From: Sue Howell [REDACTED]
Sent: 11 September 2019 16:45
To: Planning.Responses <Planning.Responses@arun.gov.uk>
Cc: Anita Gardner <Anita.Gardner@arun.gov.uk>
Subject: RE: Planning Consultation on LU/248/19/DOC

Comment from Greenspace

I've had a look at the latest landscape detail drawings and the Soft landscape layout dwg kCo285/01 and would comment as follows re Condition 9

APPLICATION NO: LU/248/19/DOC

Drawing Title:
Detailed Planting Plan

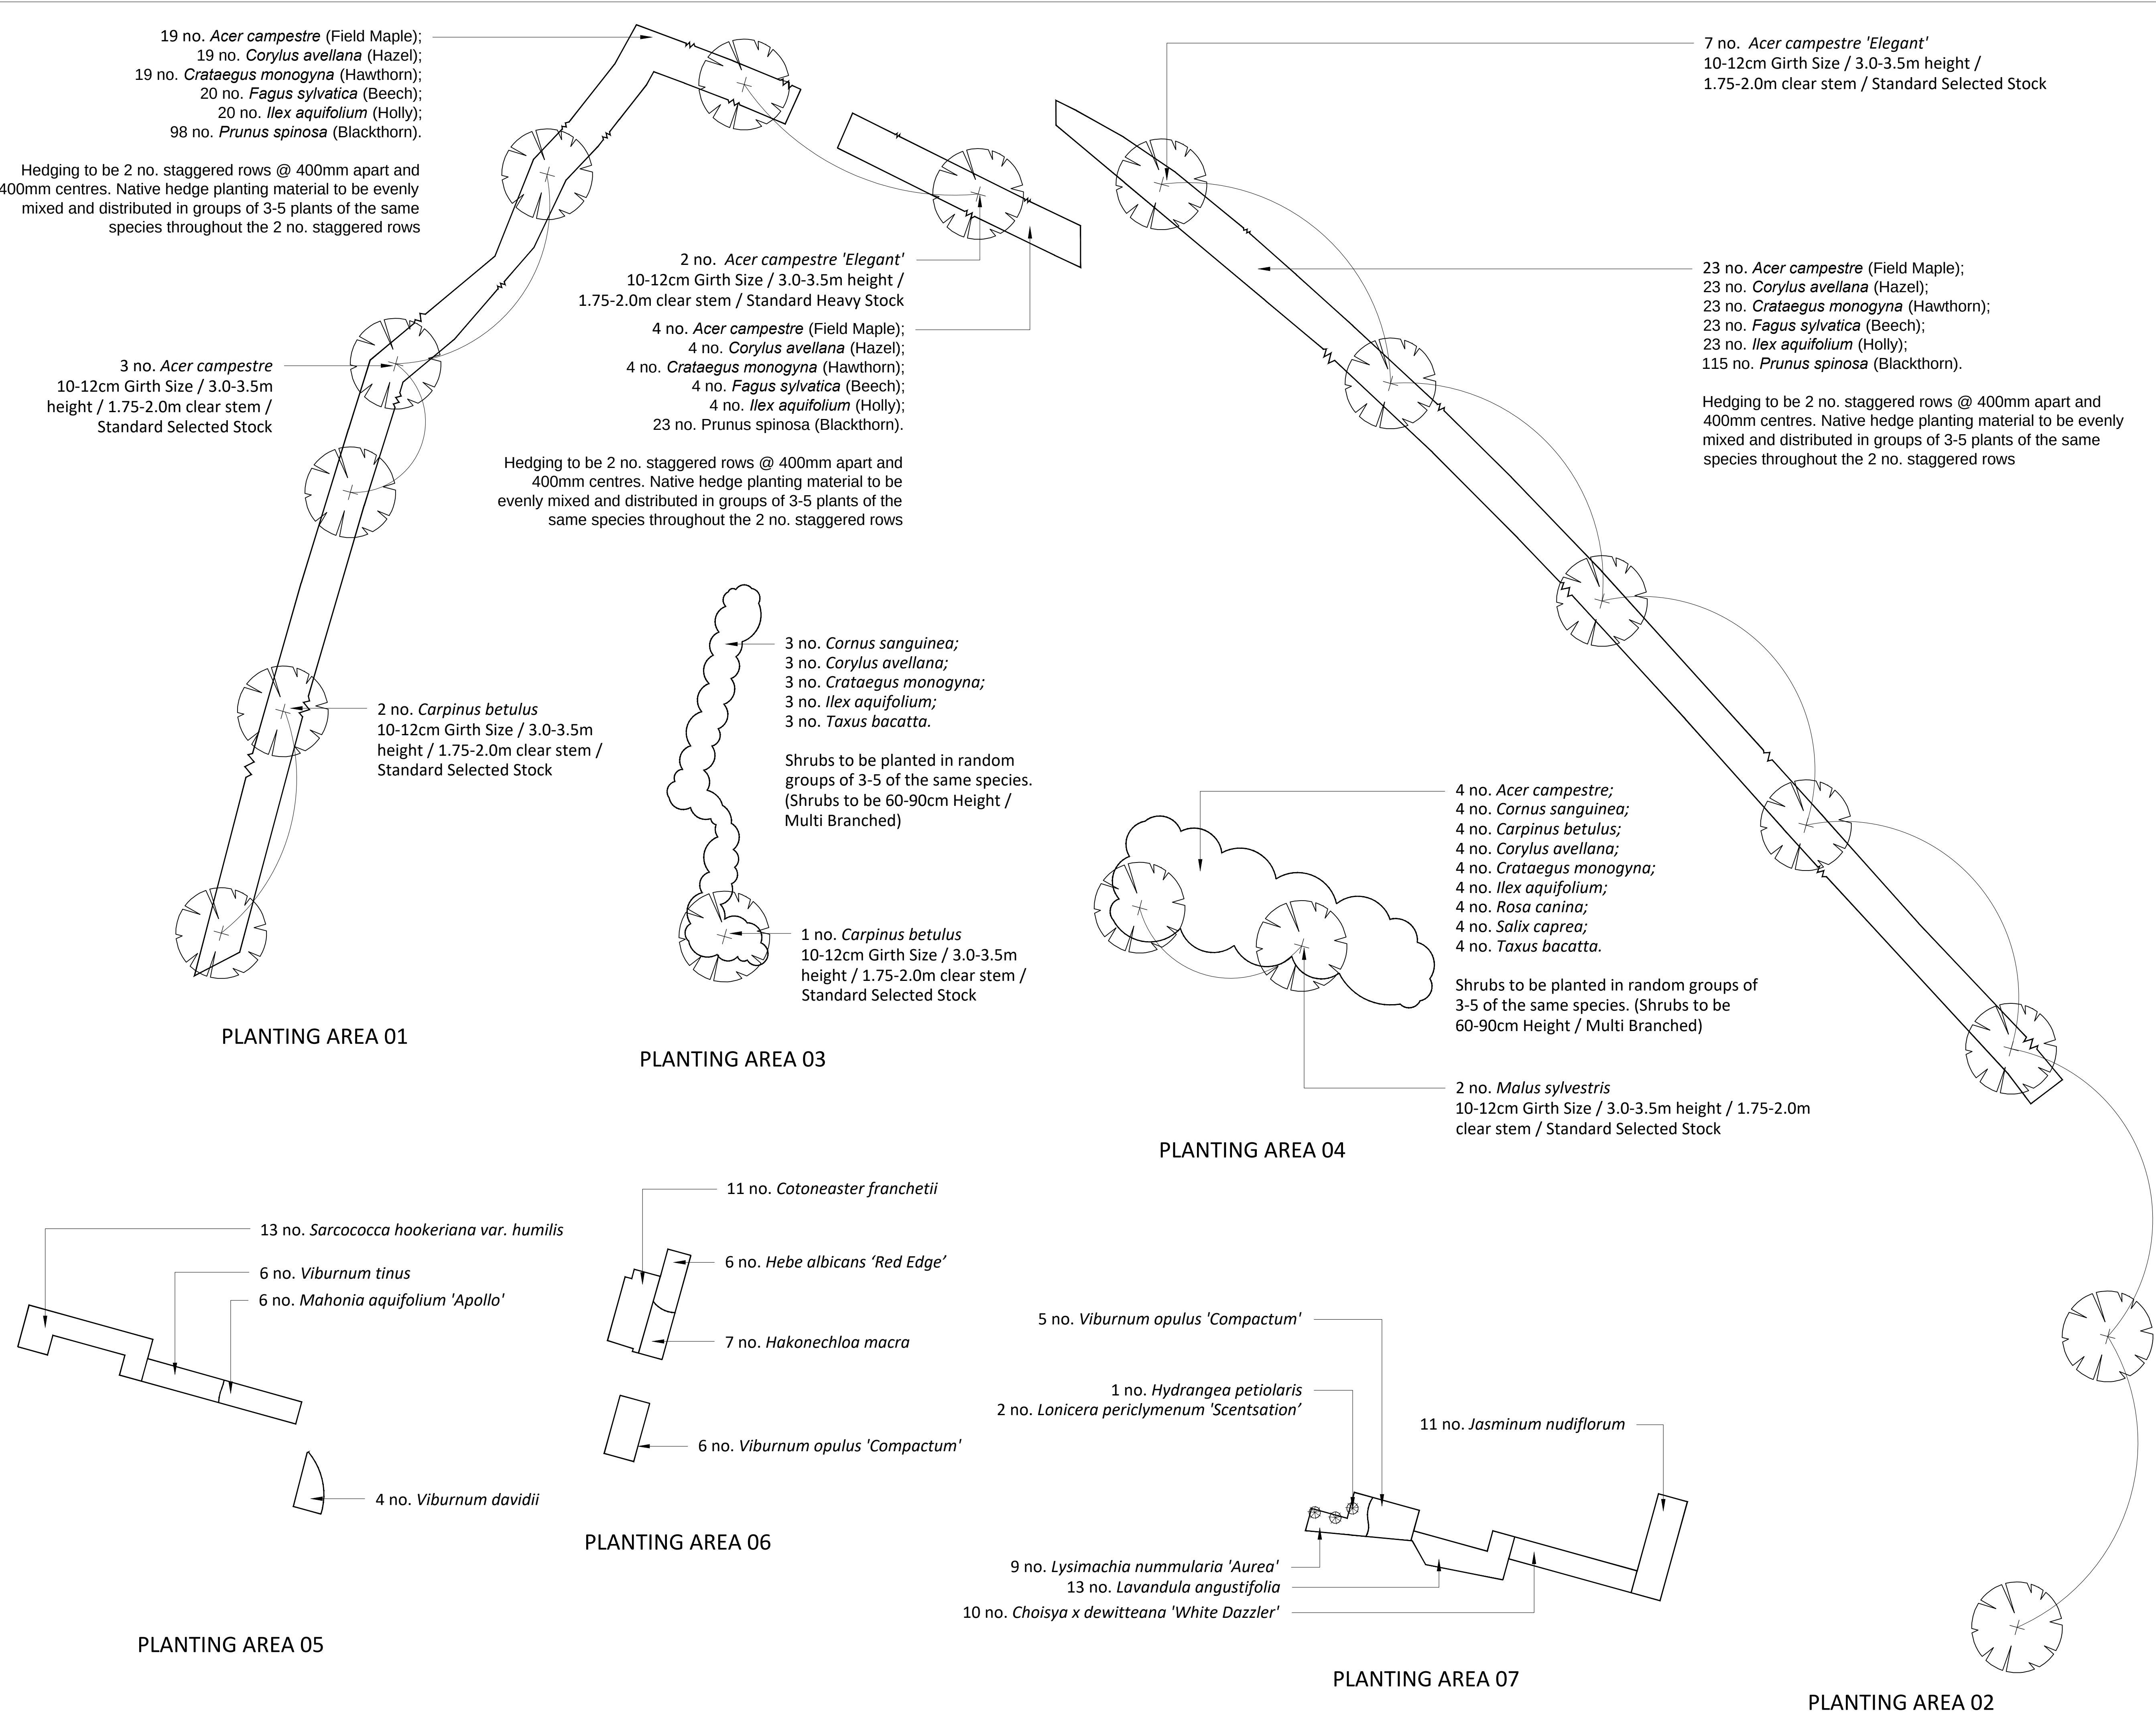
The site layout dwg submitted at approval dwg no (00) 002 rev G 20.01.17 contained a LAP within the POS area the layout dwg above now appears to omit this from the detail. Please confirm inclusion of this item.

I agree the native planting is characteristic generally of a more rural location and has the potential to become unruly if not maintained. The field maple would be an appropriate tree choice, forming a fairly compact medium tree over time. I am in agreement to the adjustment of the species mix for the hedge, reducing the blackthorn increasing the hawthorn to 60%, removing the beech and substituting the remaining 4 species x 10% each.

Planting to be adjusted in location where conflict with lighting columns occurs.

I would be happy to recommend the discharge of condition 9 once the confirmation and adjustment of detail and minor amends as listed above has been confirmed and agreed.
